Inspector's Report

ABP-317831-23

Development	3 No. new 110kV underground electricity circuits.
Location	Various locations in North County Dublin between Forrest Little, Belcamp, Clonshaugh and Harristown.
Planning Authority	Dublin City Council and Fingal County Council.
Applicant(s)	Electricity Supply Board
Type of Application	Application for approval under section 182A of the Planning and Development Act, 2000 as amended.
Prescribed Bodies	Department of Housing, Local Government and Heritage, Dublin Airport Authority, Inland Fisheries Ireland.
Observers	Patrick Murphy, Respond Housing Association, HPREF Ireland Horizon DAC.

M1 MOTORWAY CROSSING FOR FORREST LITTLE - BELCAMP DOUBLE CIRCUIT 110 kV & 220 kV CABLE: PLAN
SCALE 1:500

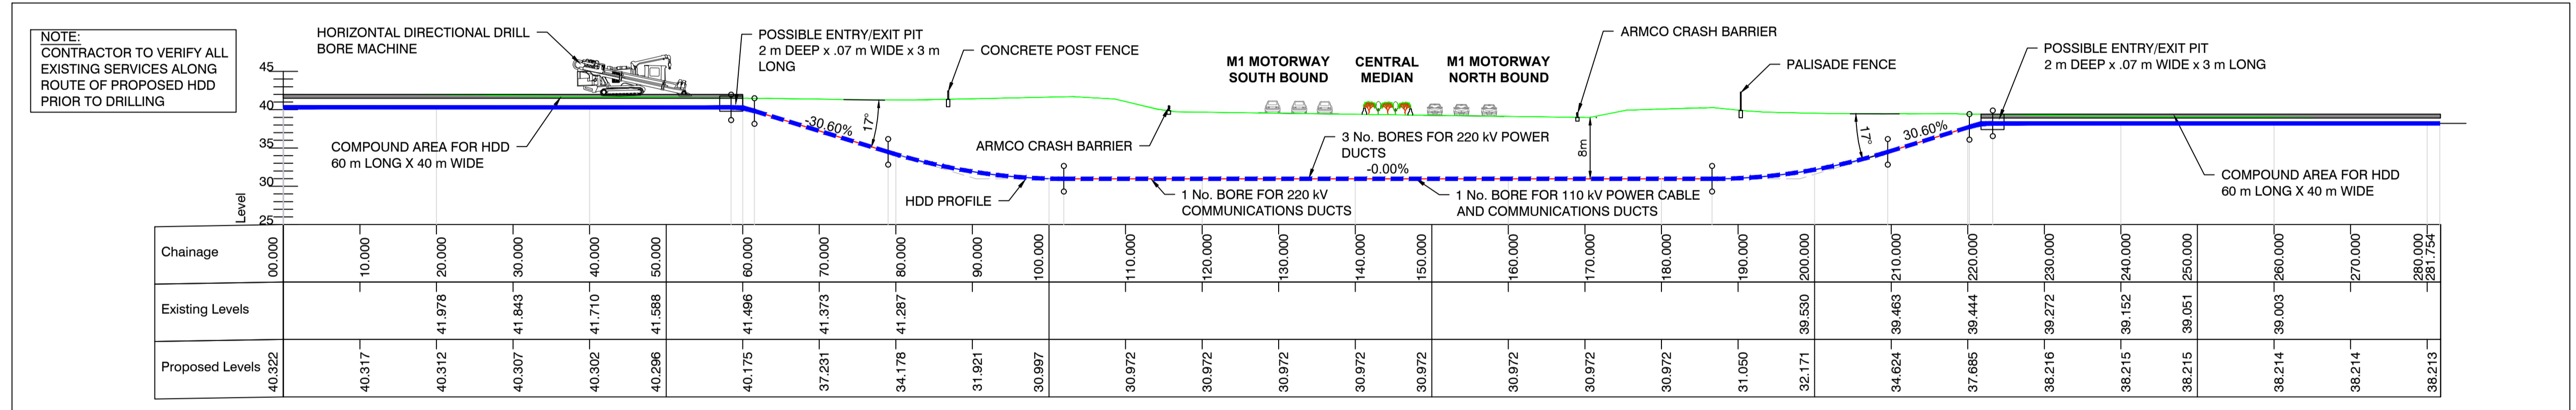
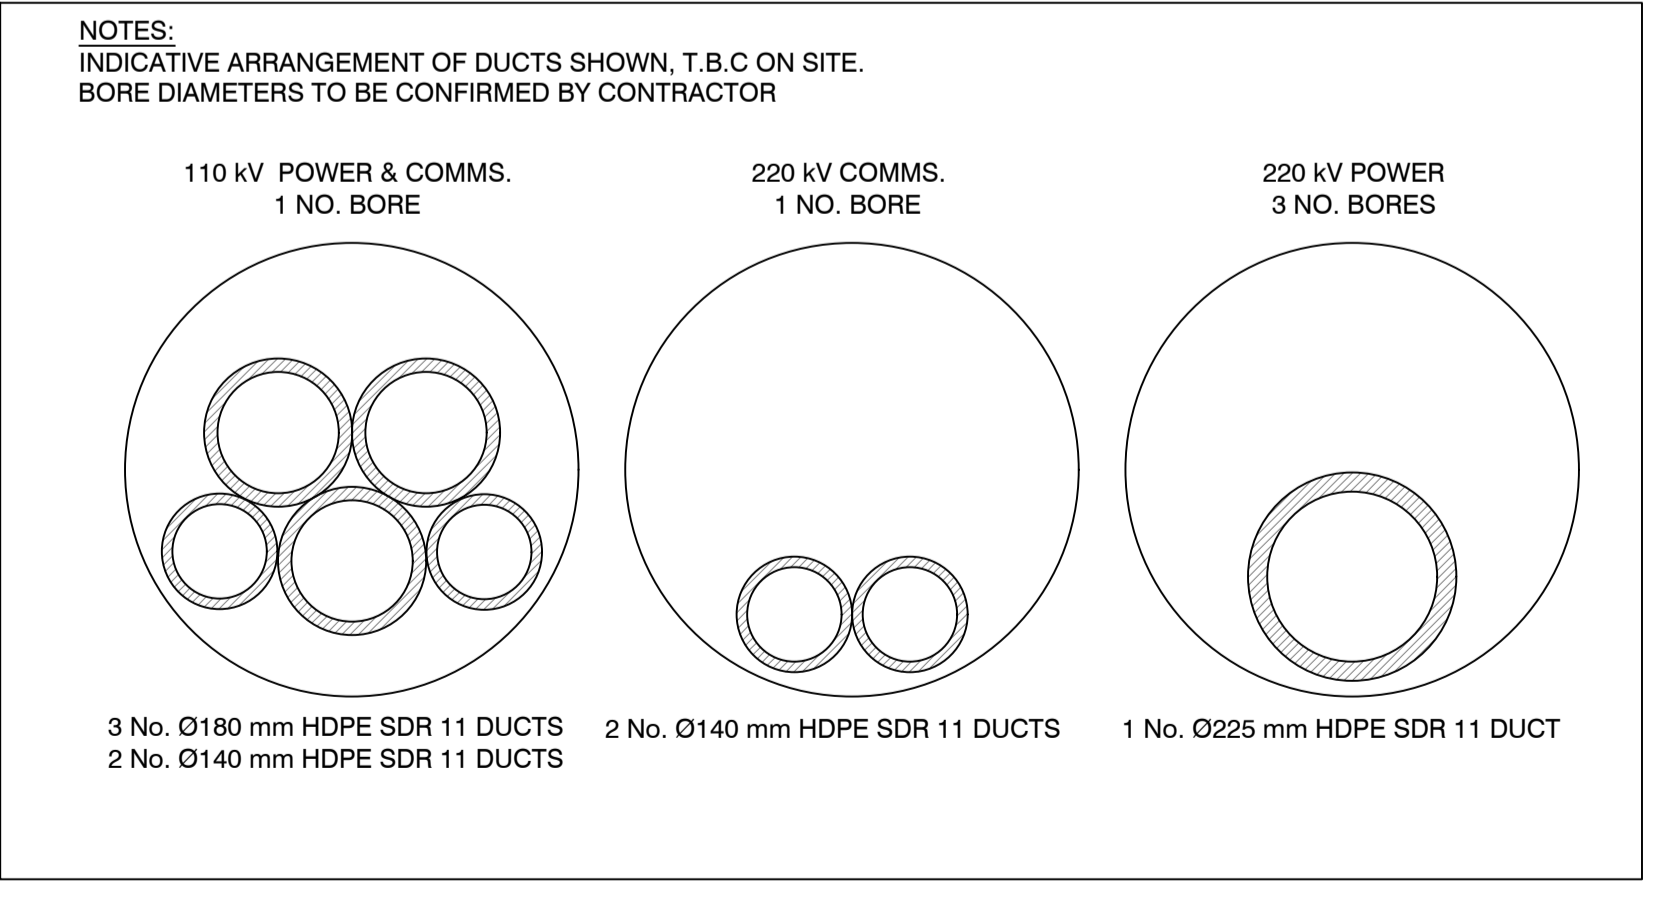
- Necessary FCC or TII consents shall be in place prior to commencement of construction.
- Design details of the M1 crossing shall be agreed in writing with FCC and the NTA prior to commencement of construction.
